REFUSAL OF PLANNING PERMISSION

APPLICATION NO. 2018/0557

Proposal Demolition of existing bungalow and erection of two storey detached dwelling

At 12 Birkdale Road, Royston, Barnsley, S71 4HH

Drawing Title
PROPOSED ELEVATIONS

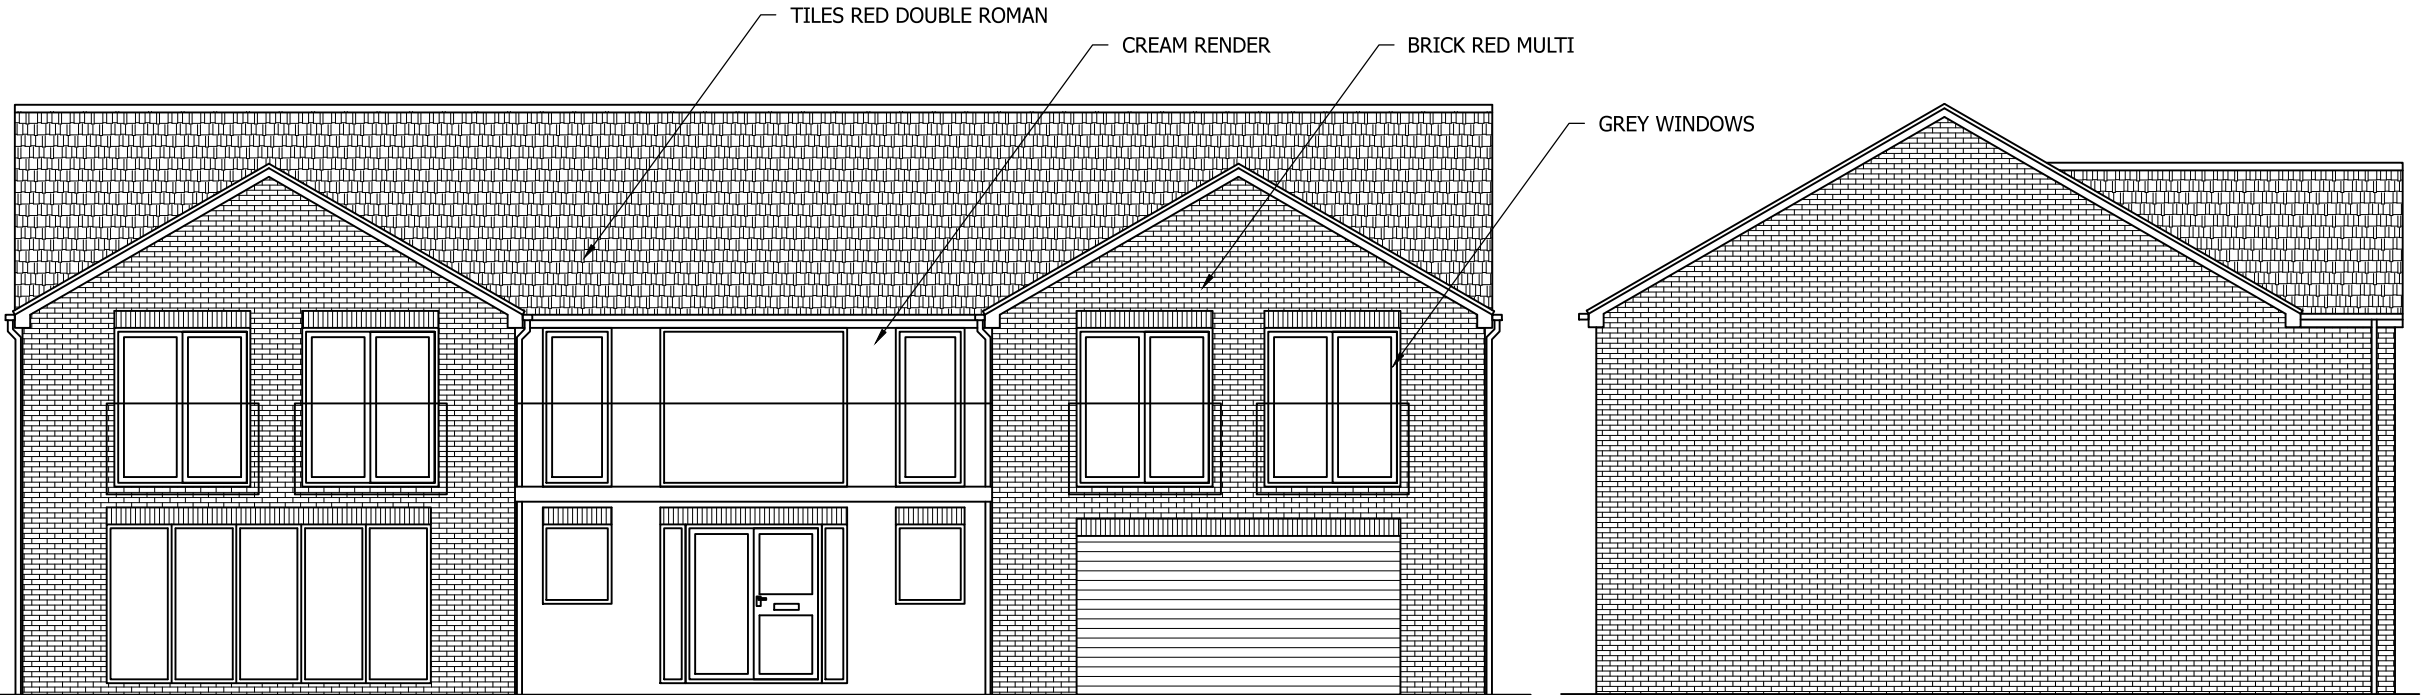
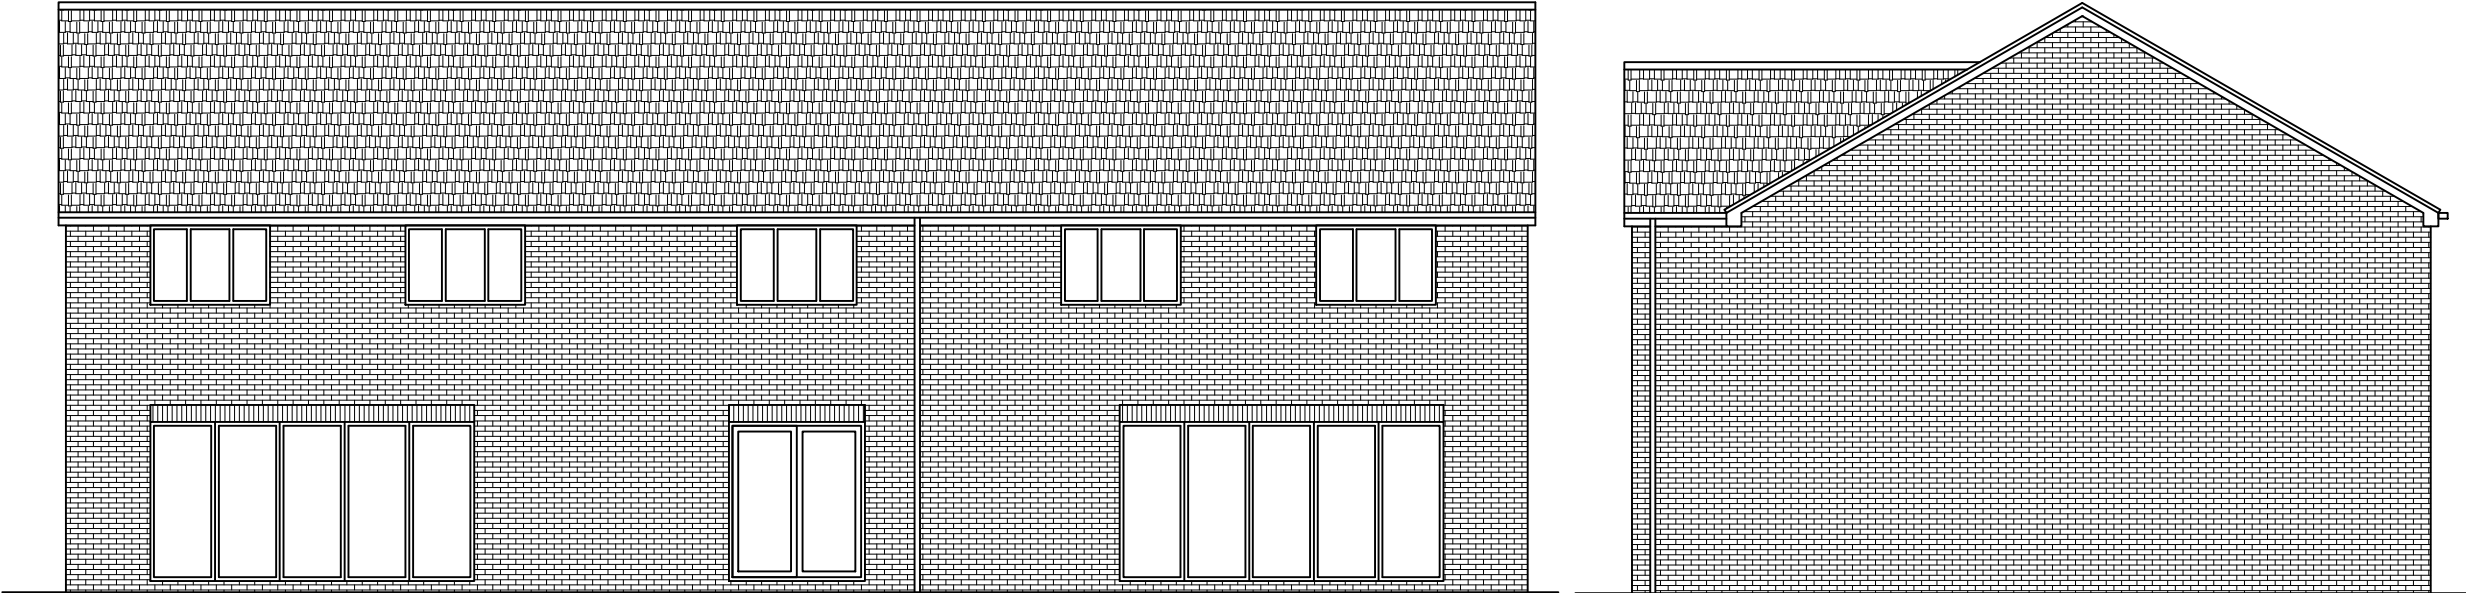
- 1 In the opinion of the Local Planning Authority the proposed dwelling would be contrary to saved policies H8A and H8D of the Unitary Development Plan, Core Strategy Policy CSP 29, the Council's Supplementary Planning Document 'Designing New Housing Development', and the NPPF, in that the design, excessive scale and massing of the dwelling on a prominent corner plot on raised land would be materially harmful to the visual amenities of the locality.
- 2 In the opinion of the Local Planning Authority, the proposed dwelling would be materially detrimental to the amenities of the occupants of the adjoining dwellings by reason of its overbearing and overshadowing impact contrary to Core Strategy Policy CSP29 and the Council's Supplementary Planning Documents (SPD) - Designing New Housing Development.
